**Our Ref: M/103/18/HH**

**Town & Country Planning Act 1990 (as amended)  
Town & country Planning (Development Management Procedure) (England) Order 2015  
Application for Planning Permission for Works or Extension to a Dwelling**

**Development** The modification of an existing balcony with the addition of privacy walls.

**Location** 46 Southdean Drive Middleton

DRAWING TITLE
 SITE LOCATION AND BLOCK
 PLANS

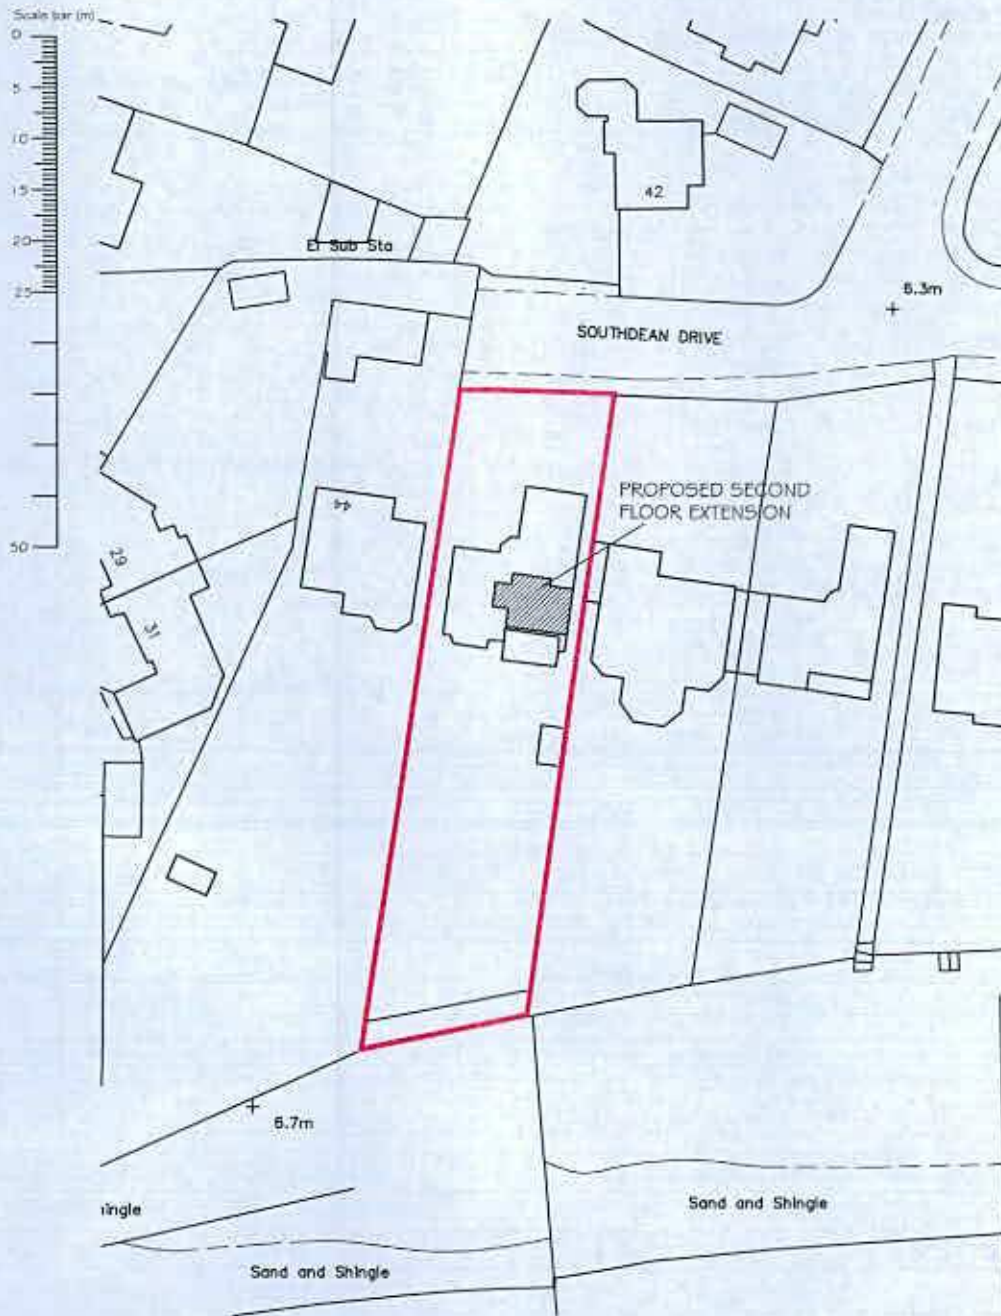
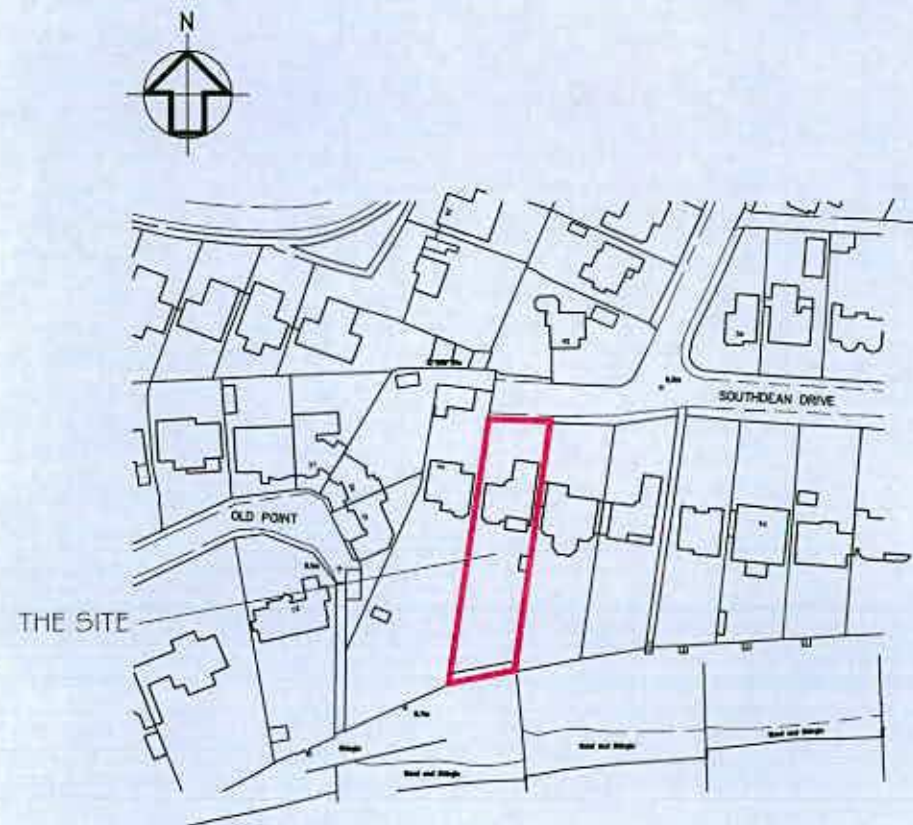
The location, block & existing plans do not scales as they have been submitted on the wrong sized paper. The drawing states they are A3 drawings but they are in fact A4. Please forward amended plans accordingly
